WEST SUSSEX COUNTY COUNCIL CONSULTATION

TO:	Arun District Council FAO:Ms Myers
FROM:	WSCC - Highways Authority
DATE:	16 April 2020
LOCATION:	102 Linden Road Bognor Regis PO21 2BD
SUBJECT:	BR/34/20/PL Change of use from 1 No. detached house (6 bedrooms) to 2 No. semi detached houses (1 x 5 bedroom & 1 x 3 bedroom) with a single storey rear extension.
DATE OF SITE VISIT:	n/a
RECOMMENDATION:	No Objection
S106 CONTRIBUTION TOTAL:	n/a / £ See below for breakdown.

DRAWING: PROPOSED CONVERSION
PROPOSED SITE PLAN

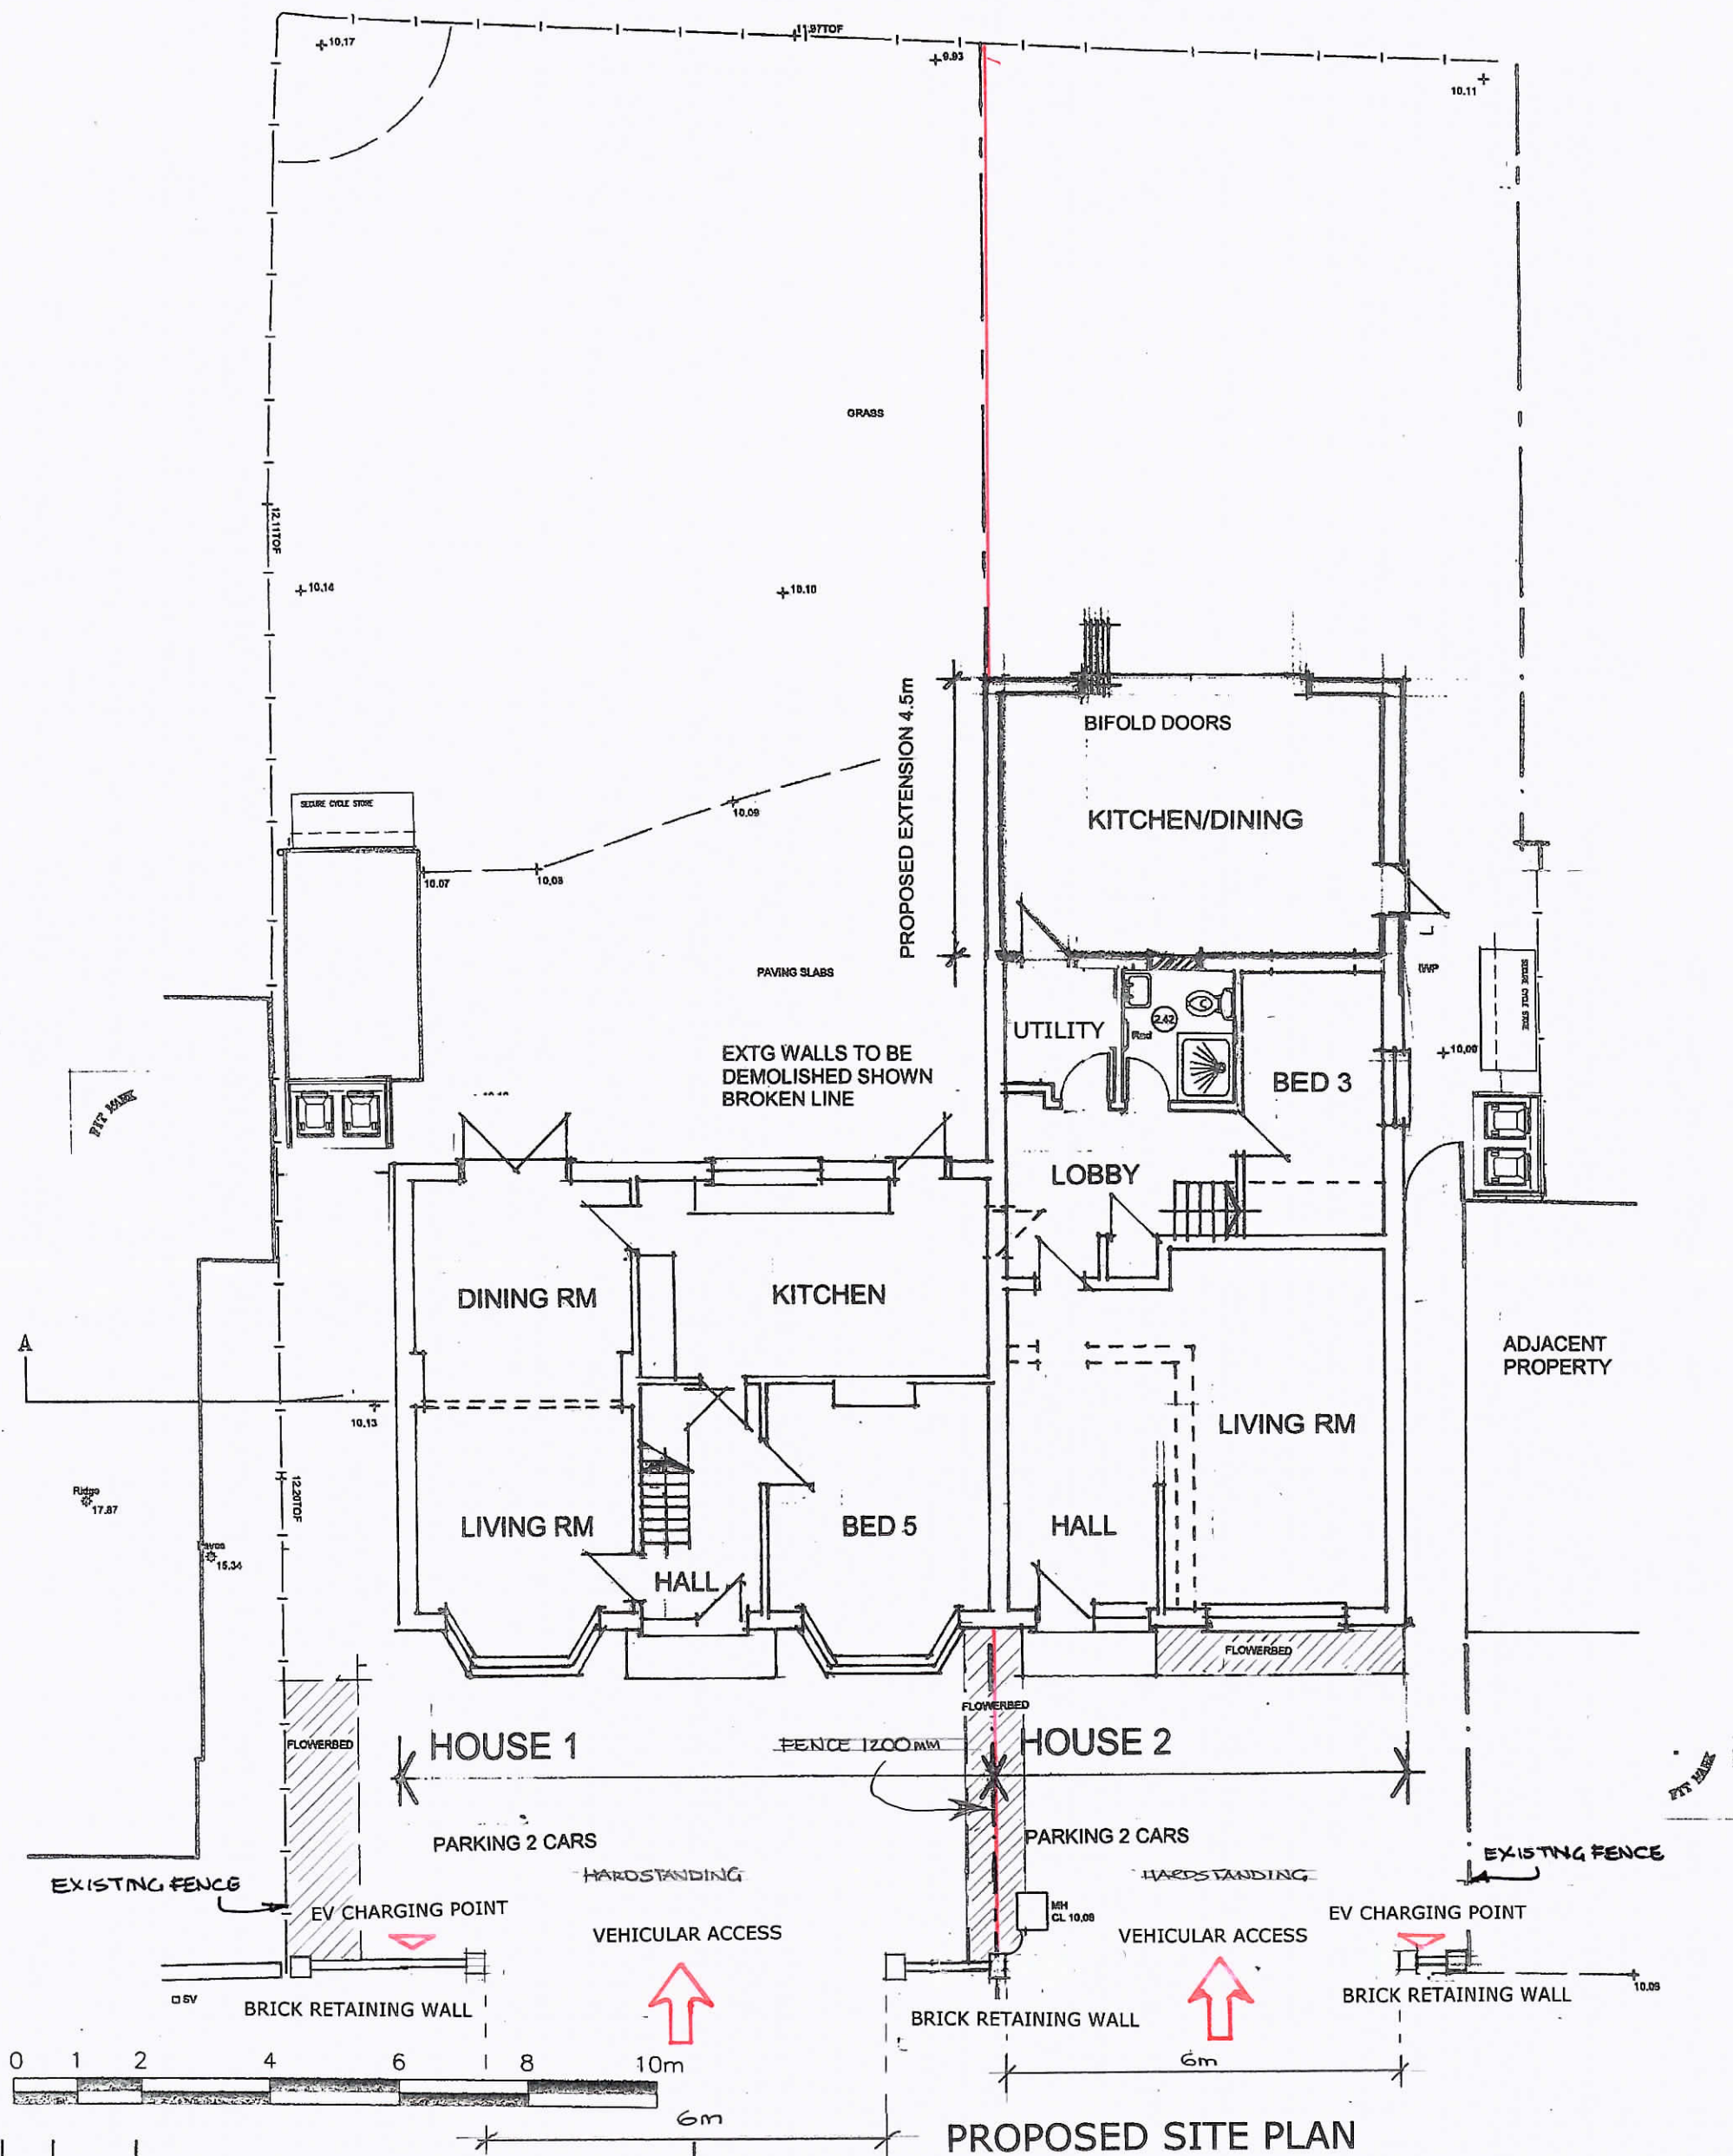
The site will create two off street car parking spaces and as such the applicant will need to apply for a minor work licence (small scale 278 agreement see informative). Linden Road does not have any parking restrictions and WSCC do not consider there to be any street furniture or trees that would be affected by this proposal. No objection
